October 12, 2023

Re: White Barn – Chick-fil-A – *Technical Review 1*
PA23019

After reviewing the application materials for the above referenced proposal, the following technical review comments are provided below.

PRELIMINARY TRUCK TURNS FOR CHICK-FIL-A MARYSVILLE

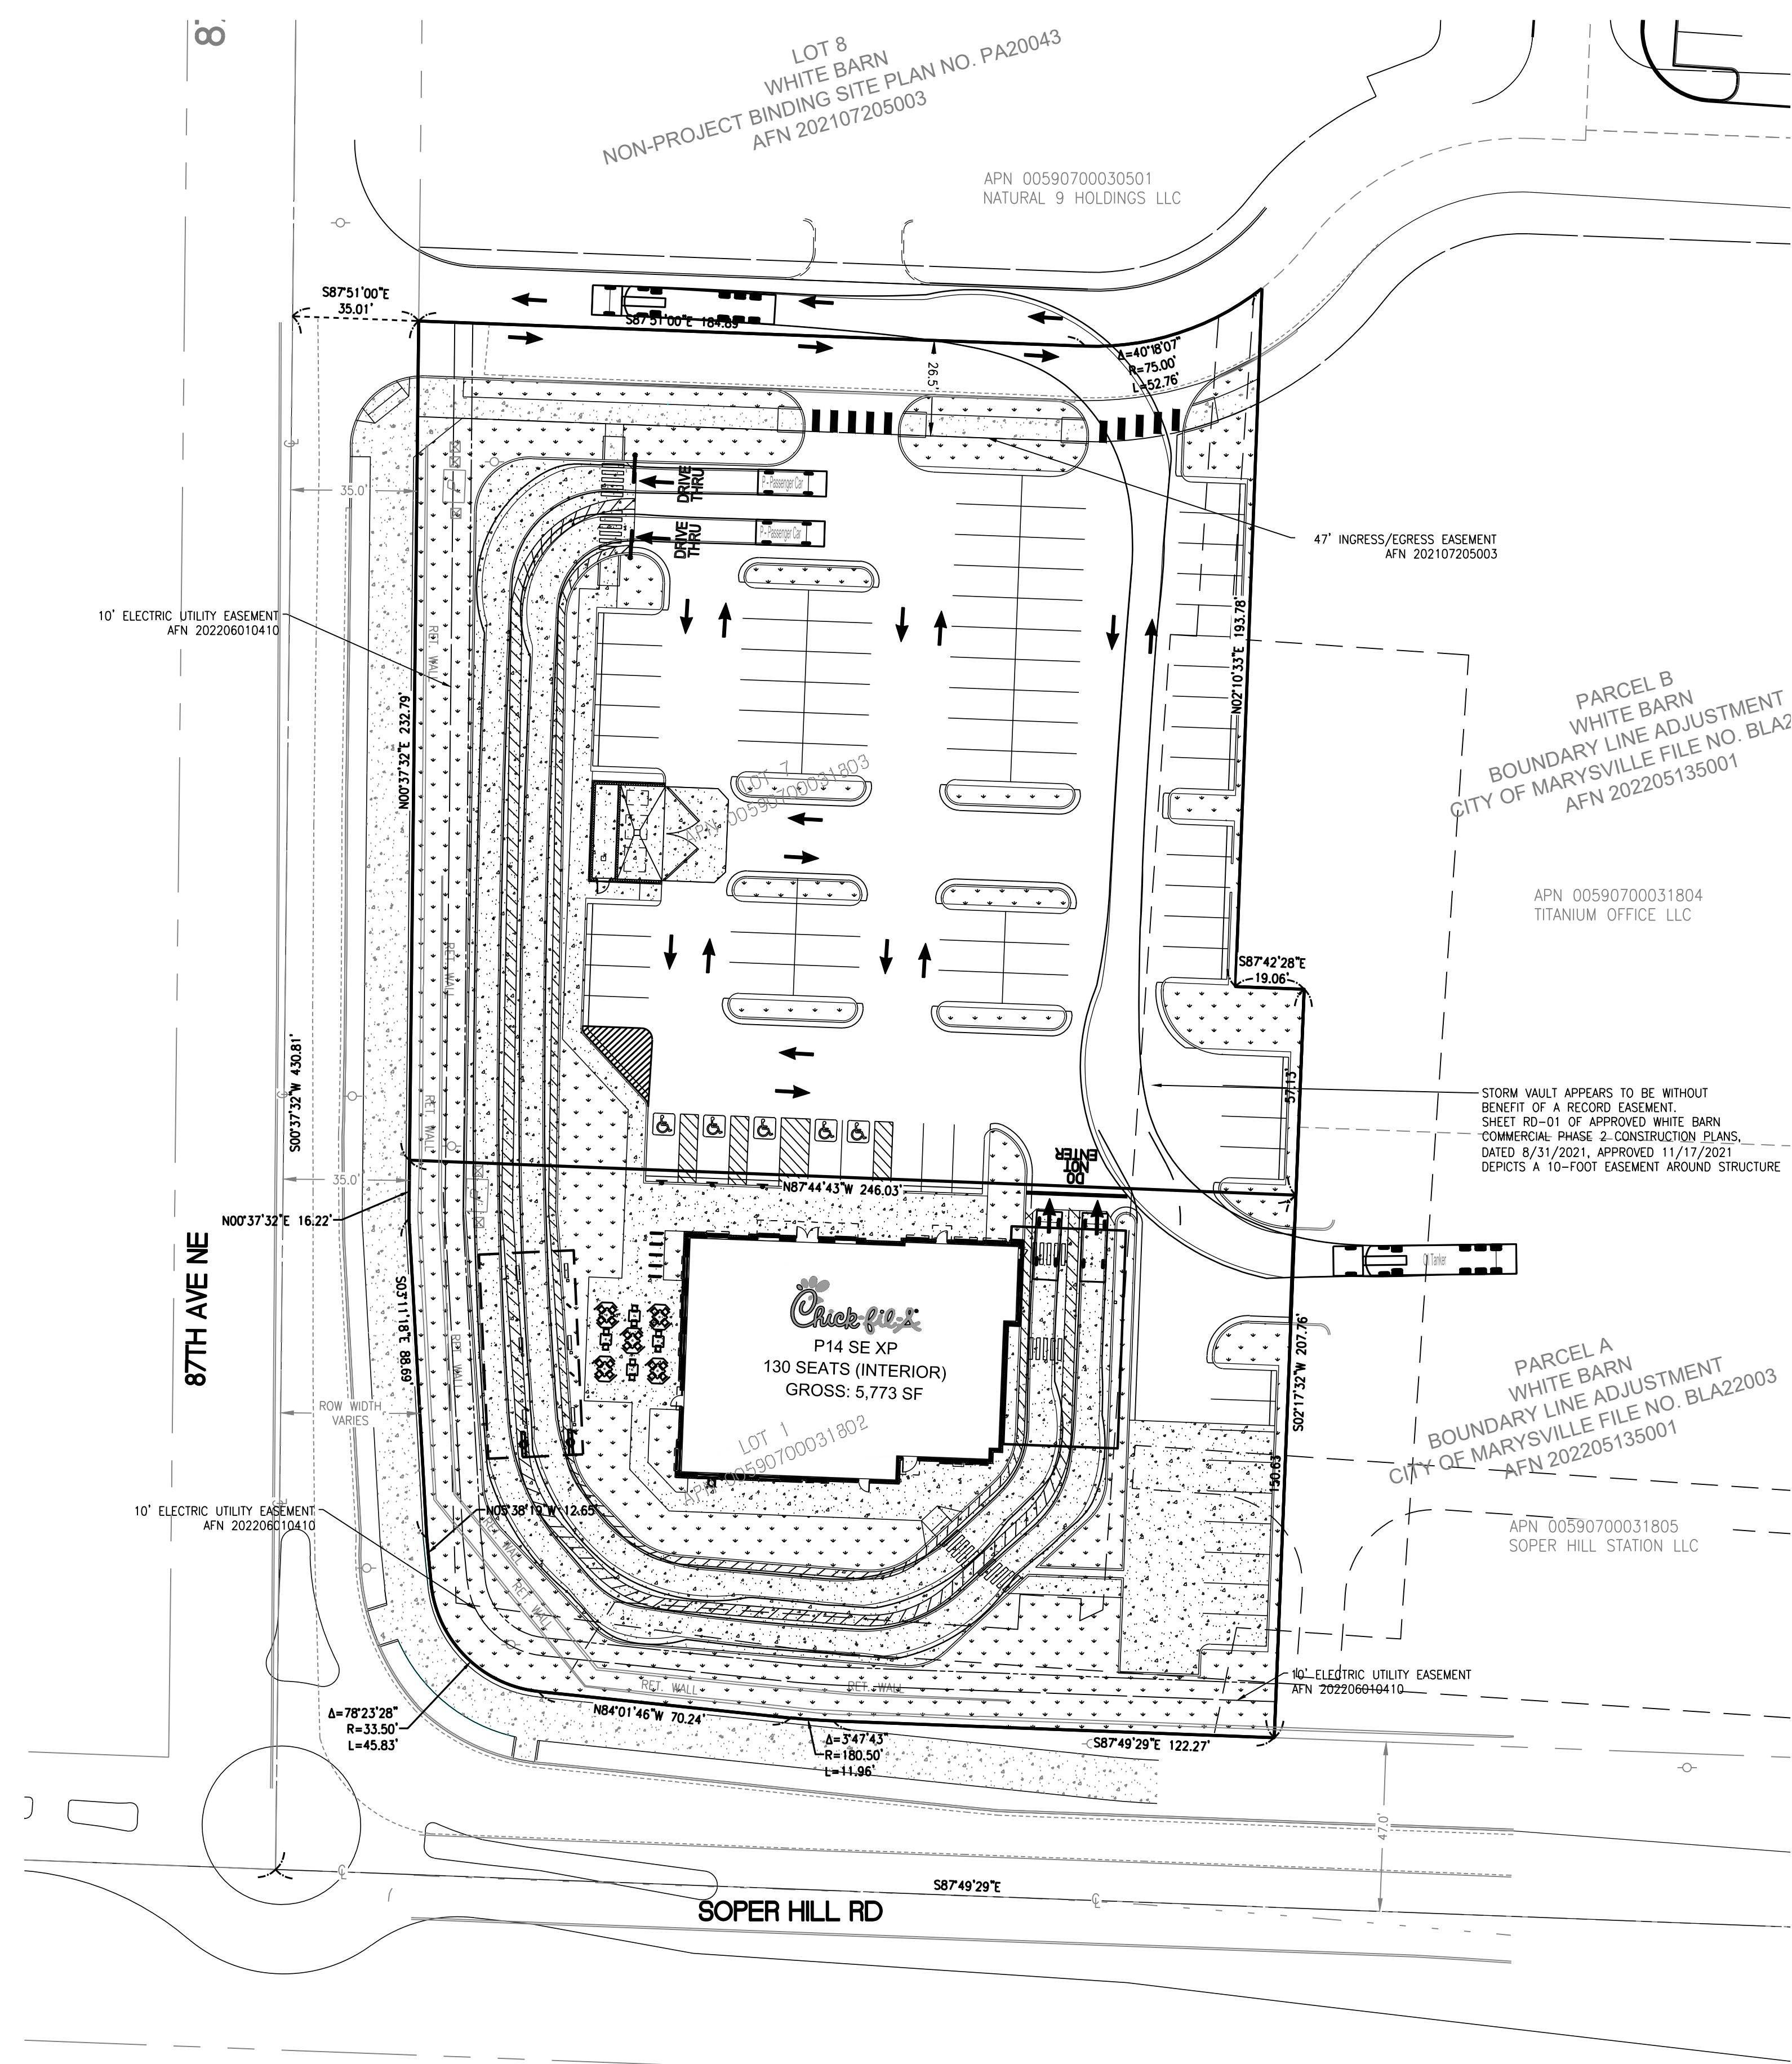
- h. Provide auto-turn from the north private drive demonstrating the largest vehicles using the drive-thru have adequate turning radius to enter into the drive-thru. The drive-thru appears rather close to the east-west private drive in order to make this turn. Suggested changes included on attached red lined site plan.
